**MODIFICATION TO APPROVAL MP08\_0253  
BLOCK 1 AND 4N, CENTRAL PARK, CHIPPENDALE**

On behalf of Frasers Broadway Pty Ltd, we write to request that the Minister (or his delegate) modify Project Approval MP08\_0253 under section 75W of the *Environmental Planning and Assessment Act 1979* as described below.

The modification proposed in this section 75W application comprises the installation of a second trigeneration gas engine within the Central Thermal Plant (CTP) of the existing basement of Blocks 1 and 4N, Central Park. The installation necessitates amendments to the consent conditions (as described in **Section 2.1**) but will not result in changes to any approved or proposed physical works (including structure or visible services).

| PA - A - 1757 | 09       |          |      |

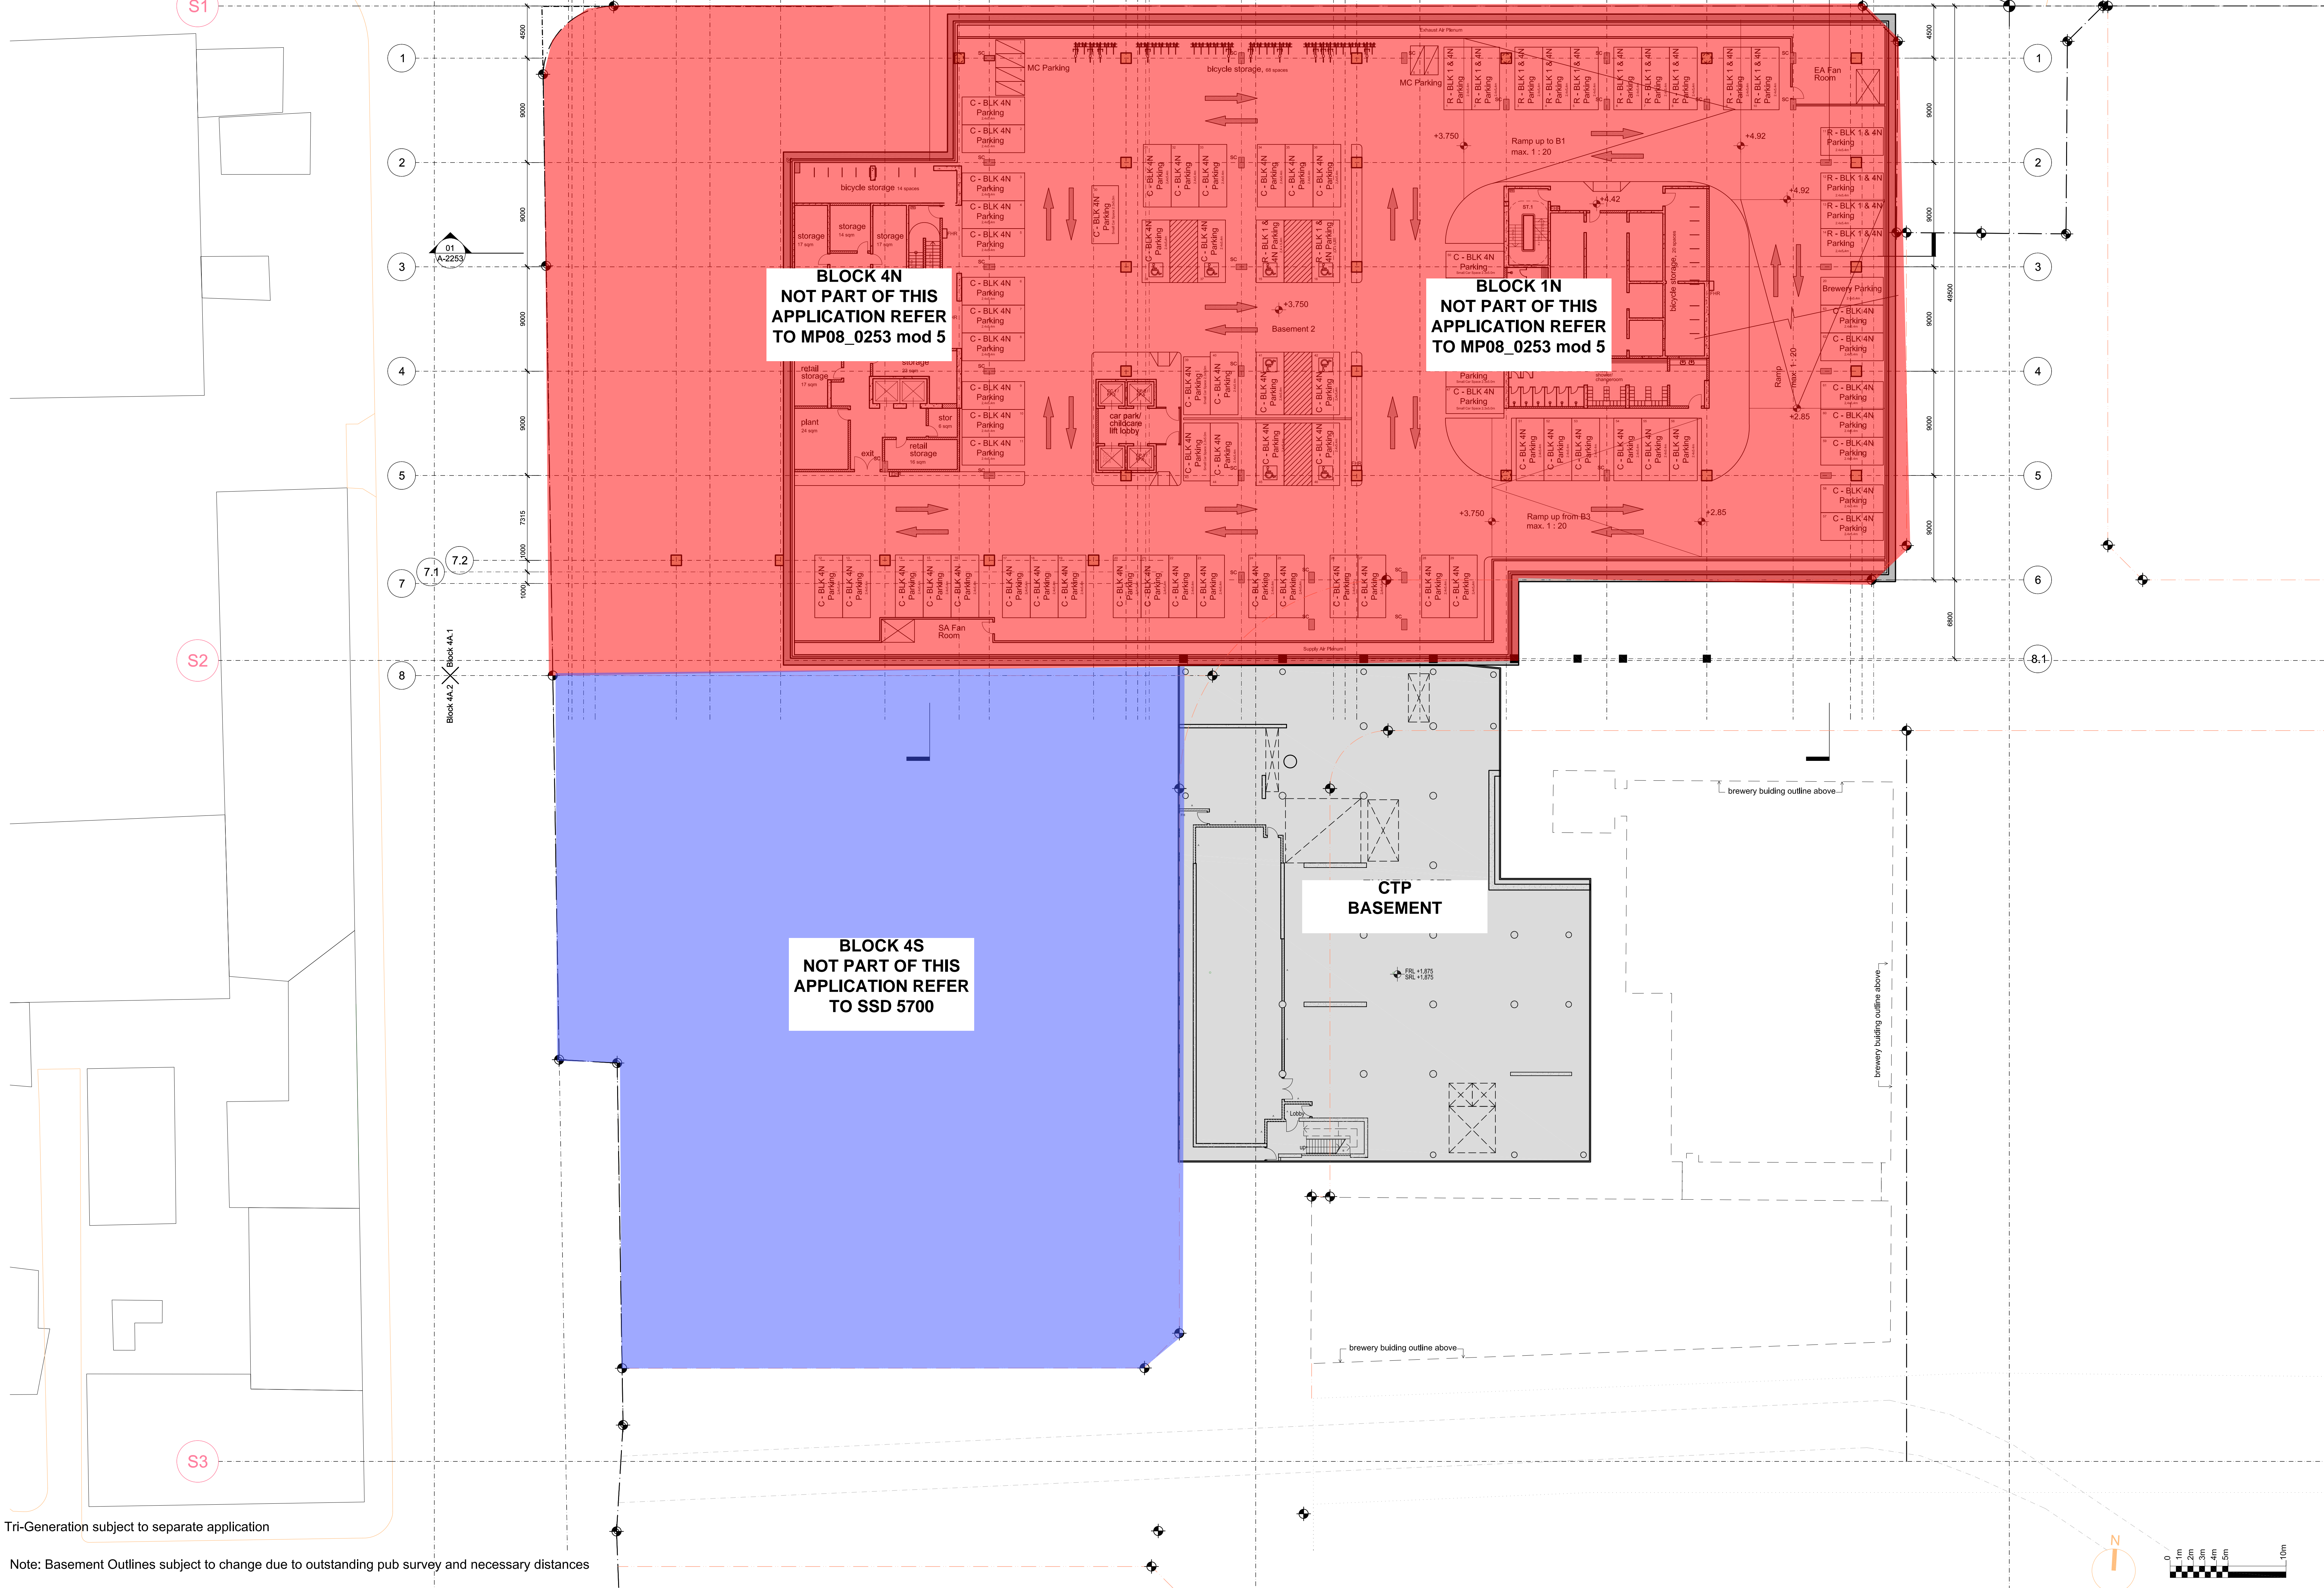
However, the CTP was left off the plans submitted as part of MP08\_0253 Mods 4 and 5. Therefore this modification is accompanied by marked-up architectural drawings PA-A-1757 (Rev 9) and PA-A-1758 (Rev 9) which show the CTP's basement location.

It is noted that in separating Blocks 1 and 4N (Mod 5) reference to the basement containing the CTP was left off the drawings. As a result, this modification seeks to reintroduce the basement and add a second engine as described above.
